## **Application by EPL 001 Ltd for Stonestreet Green Solar**

### **The Examining Authority's Second written questions and requests for information (ExQ2)**

**Issued on Tuesday 25 March 2025**

Figure 13.3: PRow Survey Results - Daily PRow Trips

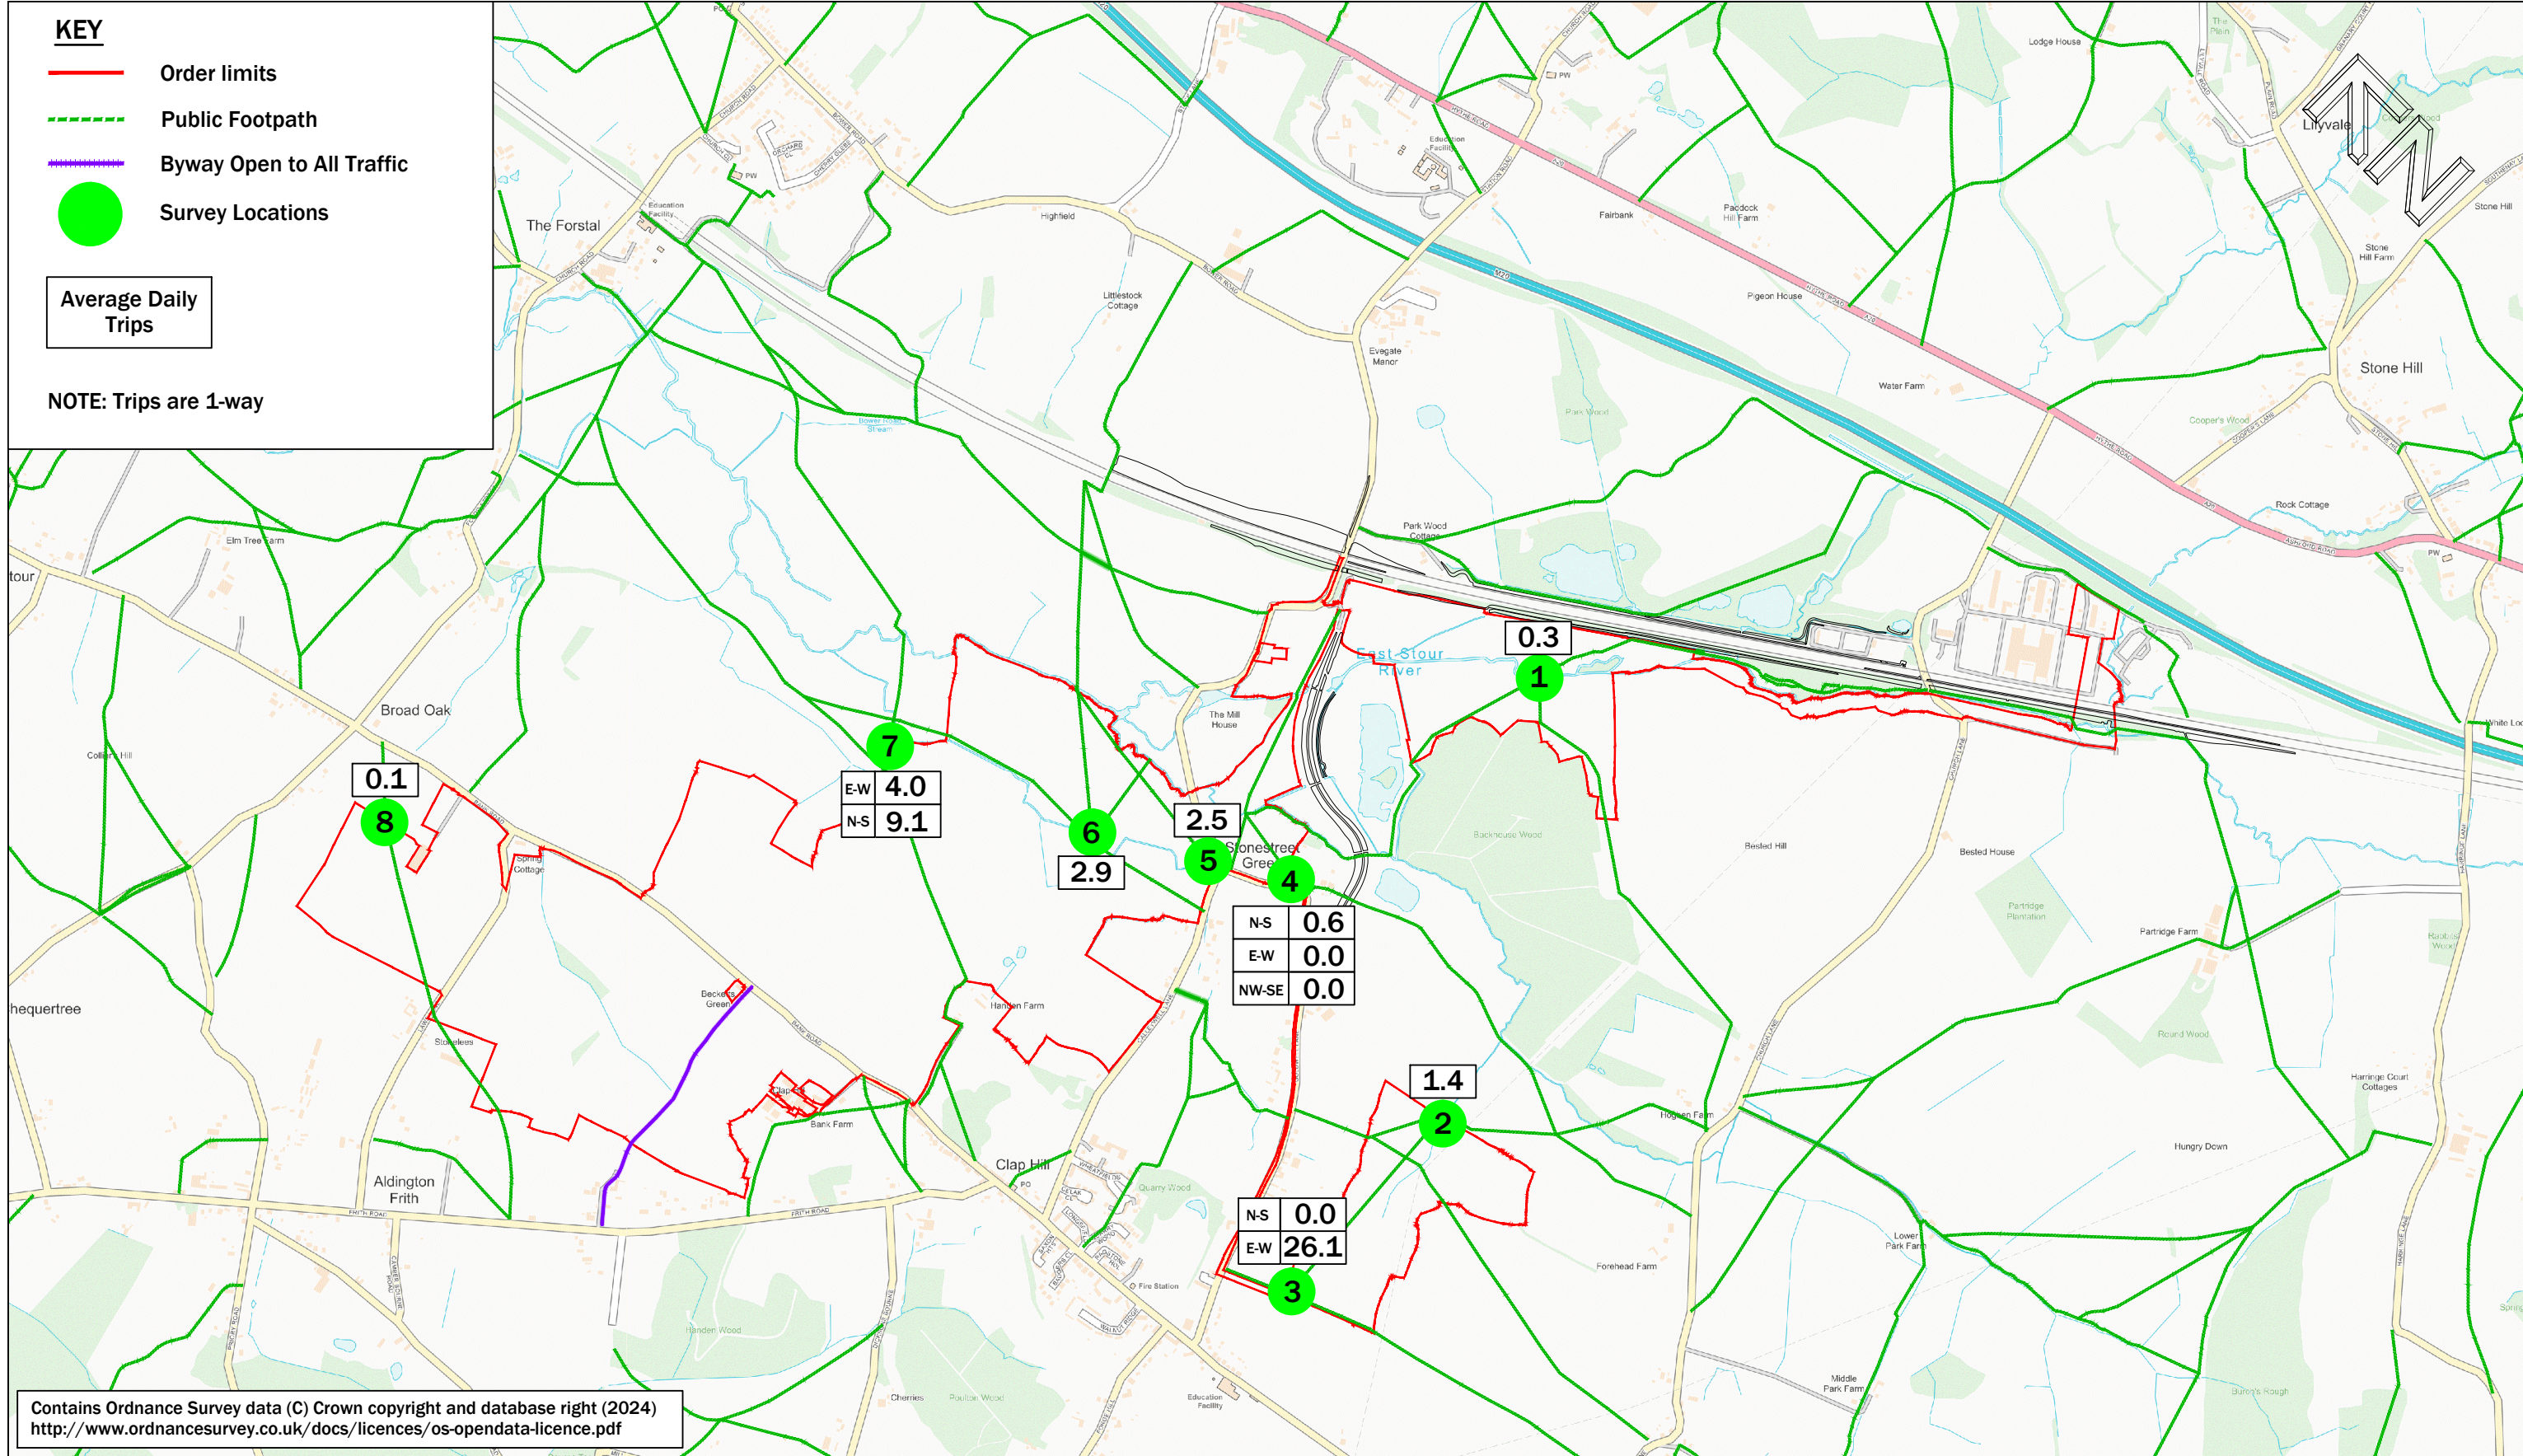
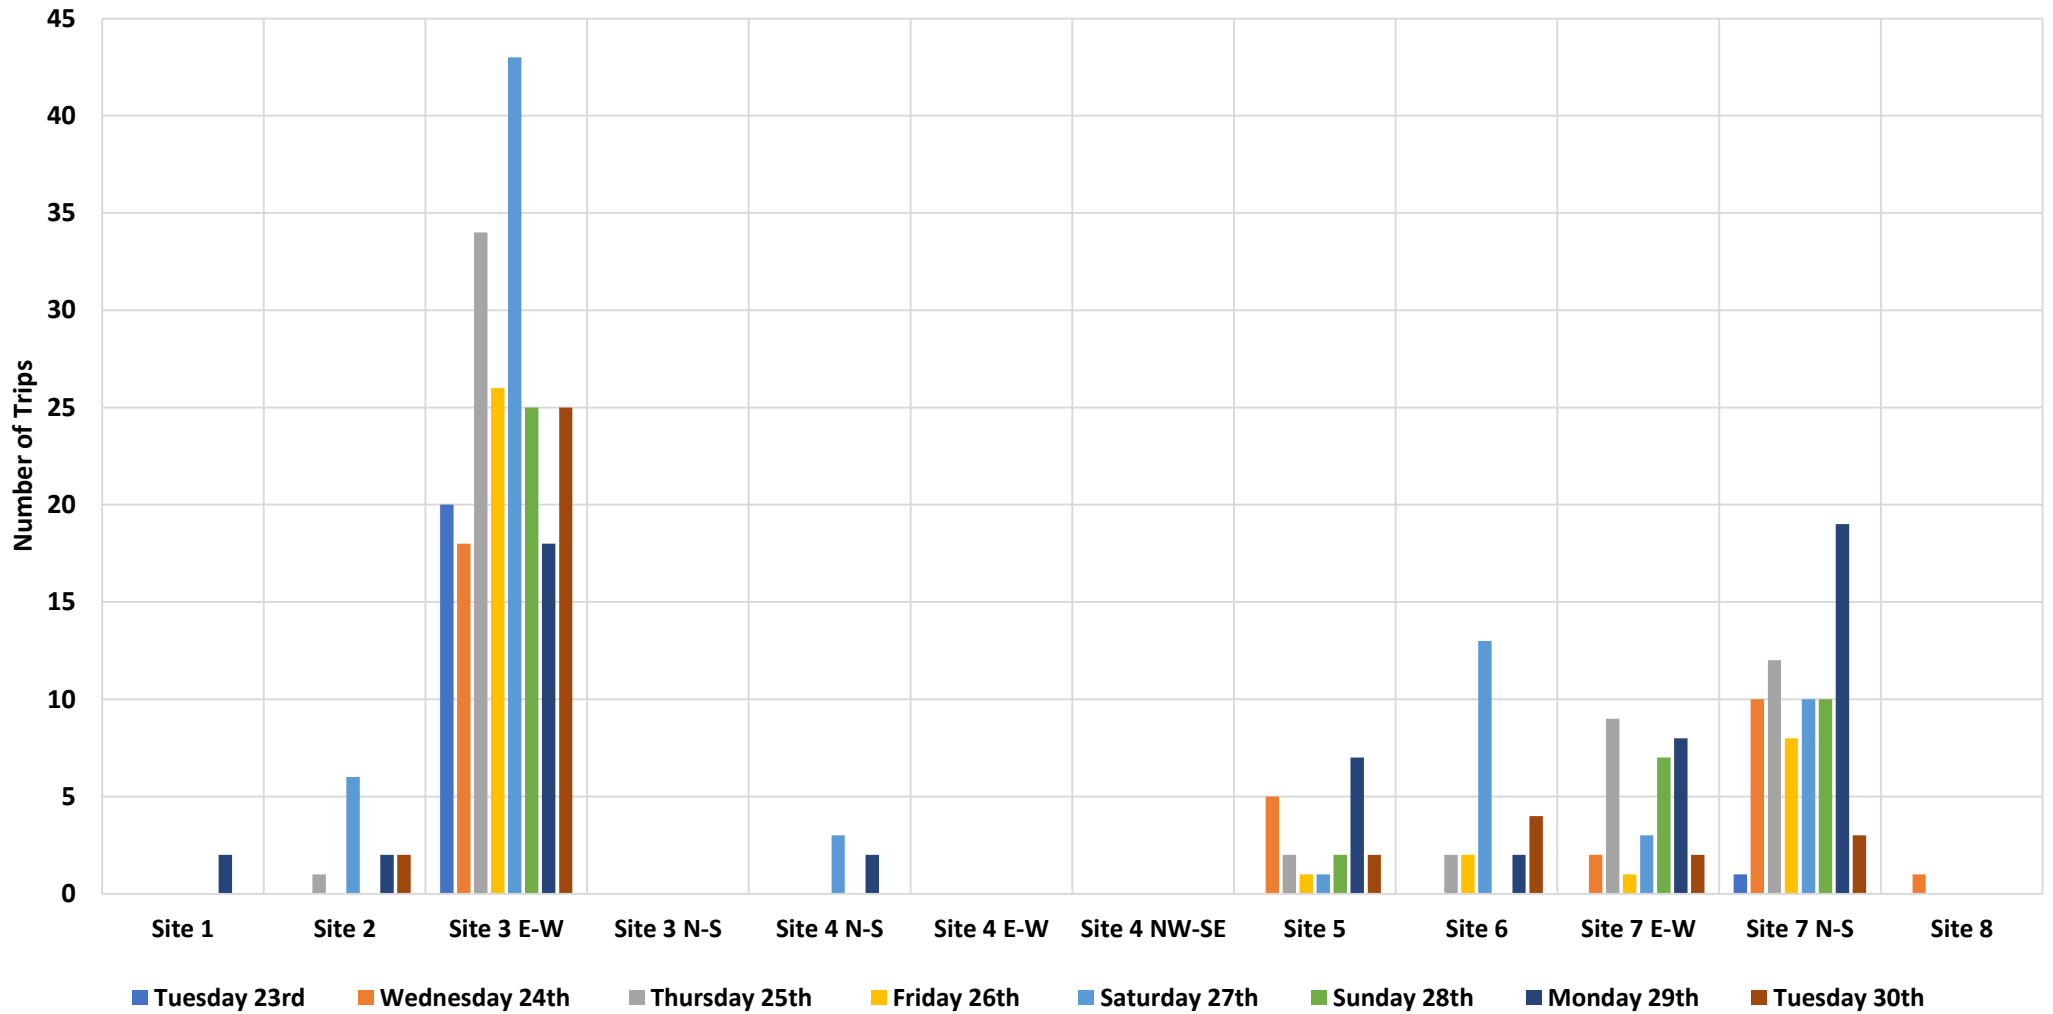
| ExQ2                        | Question to:                                 | Question:  |
|-----------------------------|--|--|
| Q5.0.2                      | ABC<br>KCC                                   | <b>Surveys - Written Submission from Applicant following ISH3 [REP4-030]</b><br><br>Action Point 2 in relation to survey results, the Applicant makes the following statement- "The results show that observations made during the Site visits that  |

| ExQ2                             | Question to:  | Question:   |
|----------------------------------|---------------|---|
|                                  |               | <p>the local PRoW network is relatively lightly used are confirmed by the survey data. This is not unexpected given that the PRoW network currently offers limited connectivity between settlements.”.</p> <p>Can the local authorities confirm that they agree with this assertion?</p>  |
